Hornsea Project Three
Offshore Wind Farm

Appendix 18 to Deadline I Submission –
Errata to the Application Documentation

Date: 7th November 2018

Figure 1.1: Strategic Road Network.

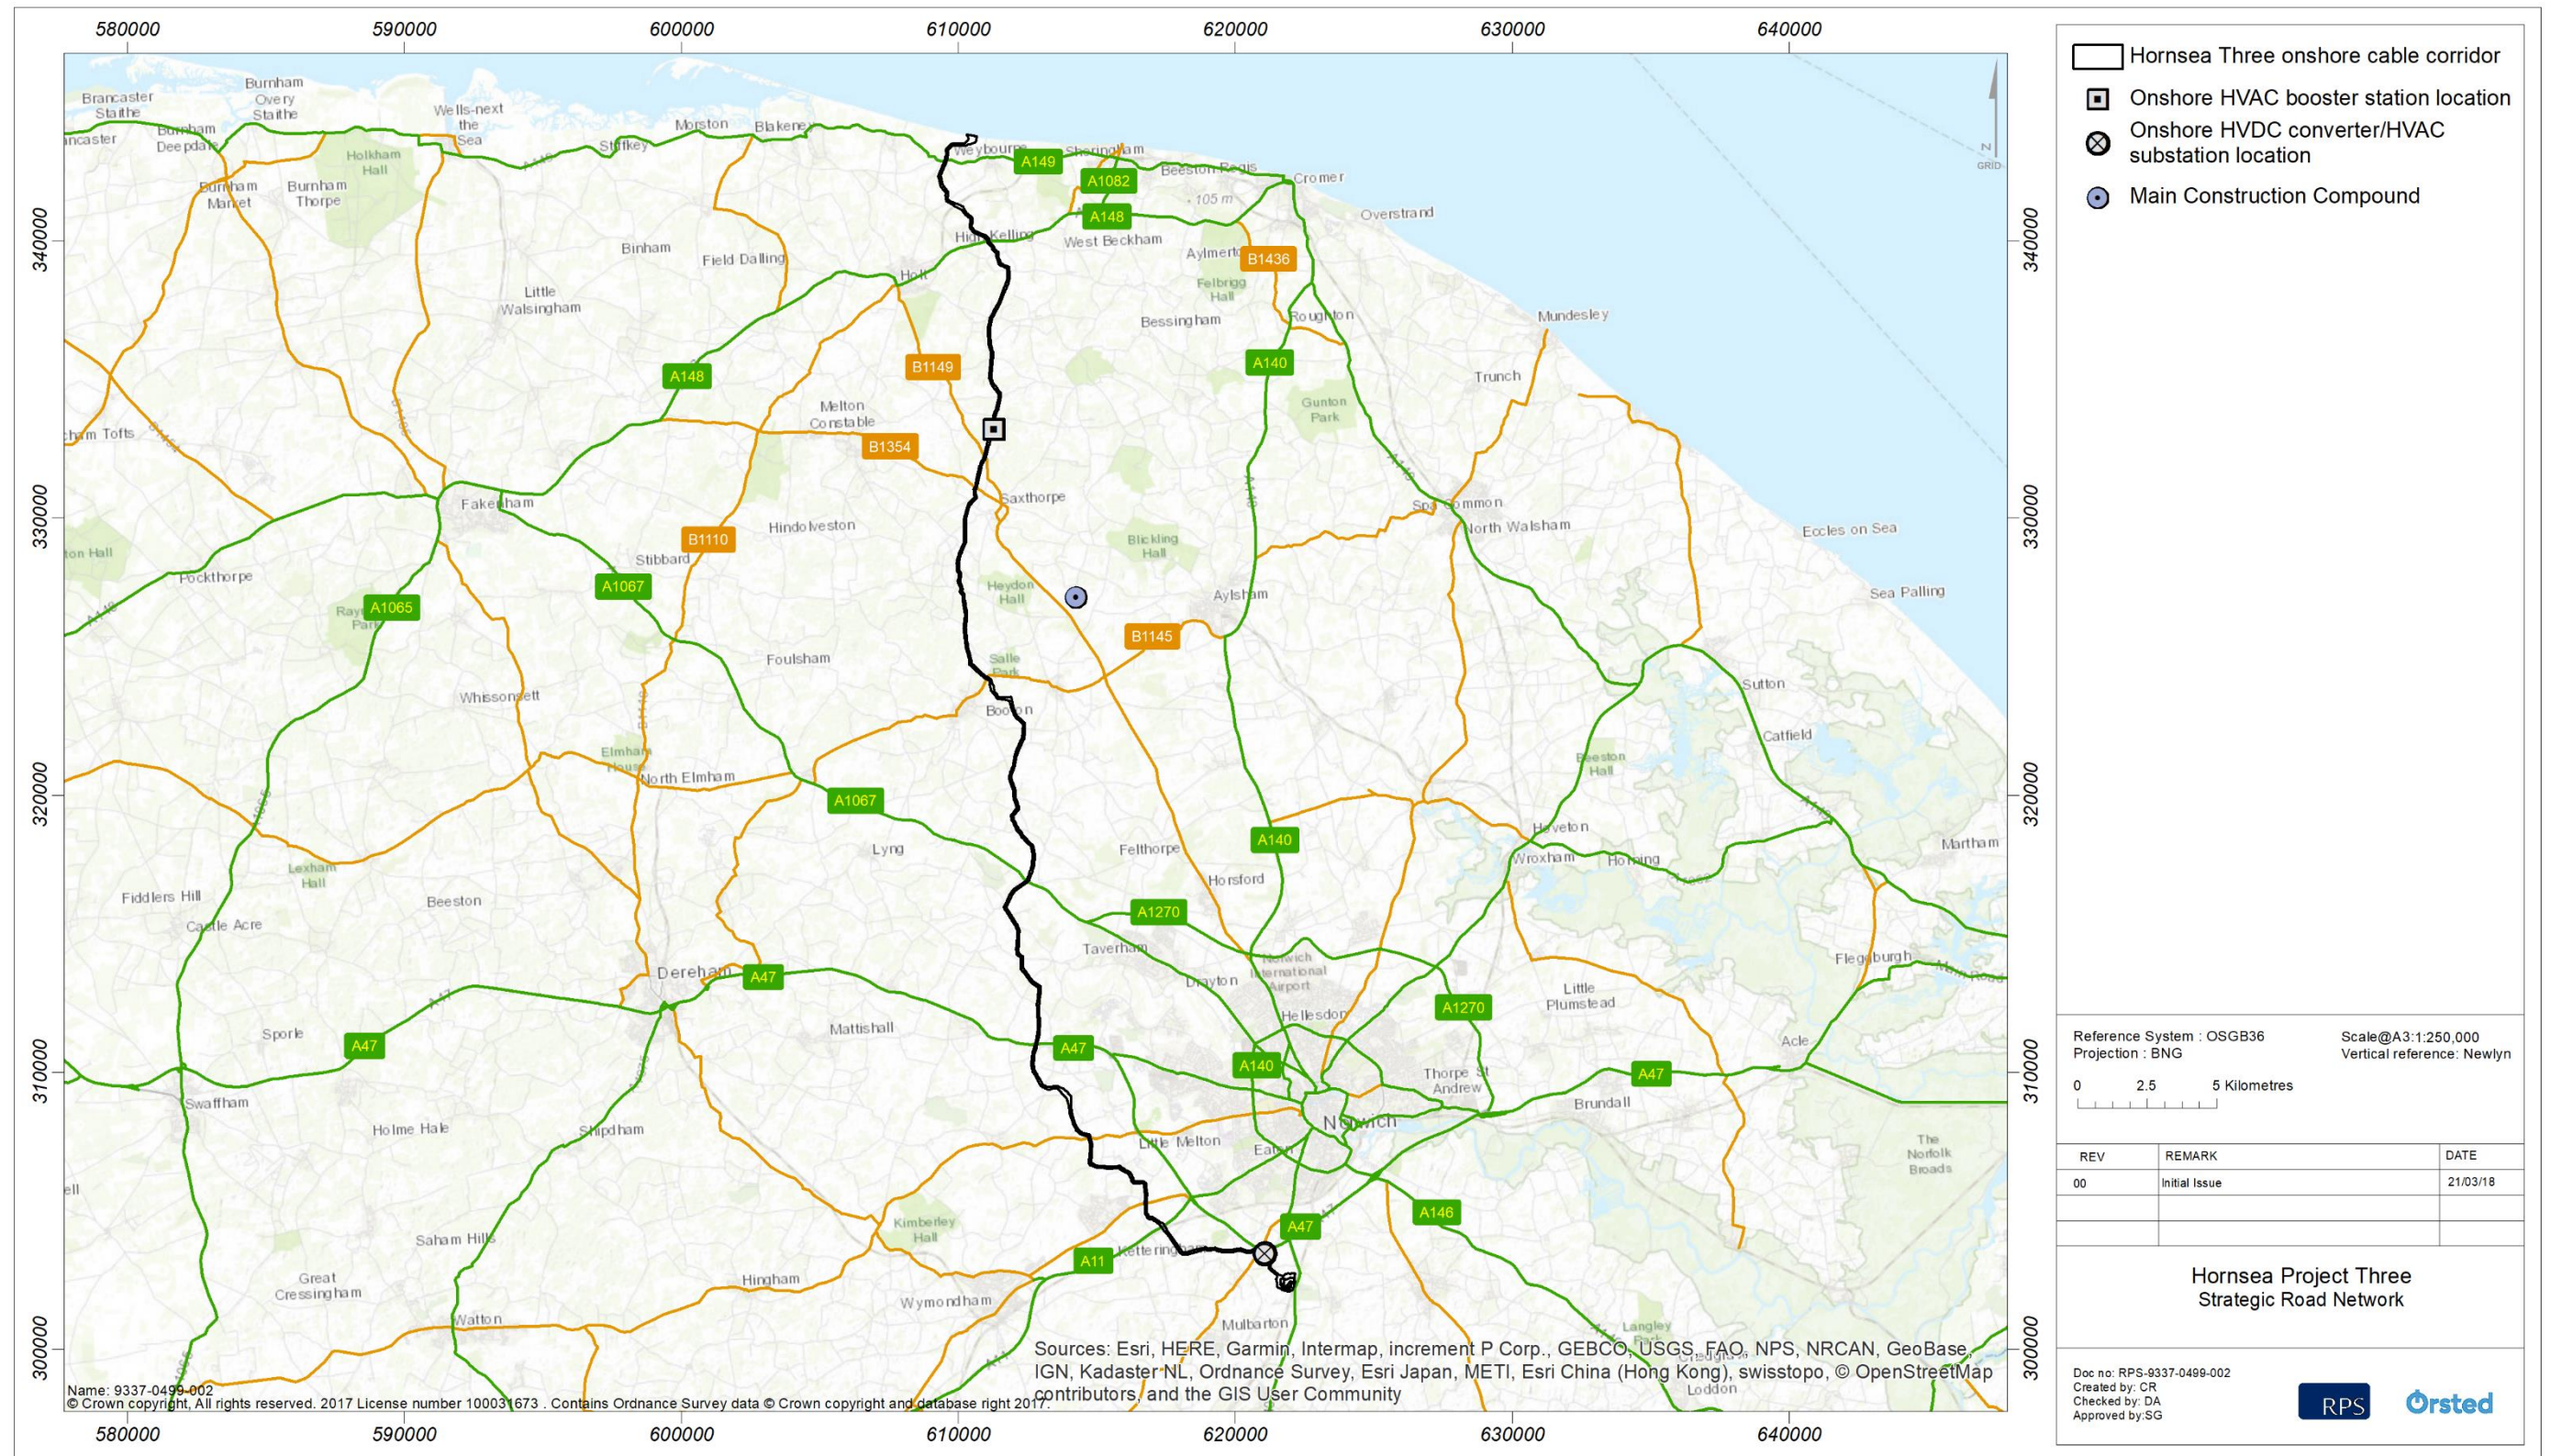
Document (As Submitted)	PINS Reference	Paragraph/ Area	Error/ Change Description	Does this change the assessment
6.3.4 ES Volume 3 - Ch 4 - Landscape and Visual Resources	APP-076	4.11.2.10	Incorrect paragraph referred to: 4.11.2.3 should refer to 4.11.2.4	No
6.3.4 ES Volume 3 - Ch 4 - Landscape and Visual Resources	APP-076	4.11.2.18	Incorrect paragraph referred to: 4.11.2.3 should refer to 4.11.2.4	No
6.3.4 ES Volume 3 - Ch 4 - Landscape and Visual Resources	APP-076	4.11.2.55	Incorrect paragraph referred to: 4.11.1.42 should refer to 4.11.2.50	No
6.3.4 ES Volume 3 - Ch 4 - Landscape and Visual Resources	APP-076	4.11.2.64	Incorrect paragraph referred to: 4.11.2.64 should refer to 4.11.2.50	No
6.6.7.8 ES Volume 6 – 7.8 Traffic and Transport Figures	APP-166	Traffic and Transport Figures	B149 should be B1149	No
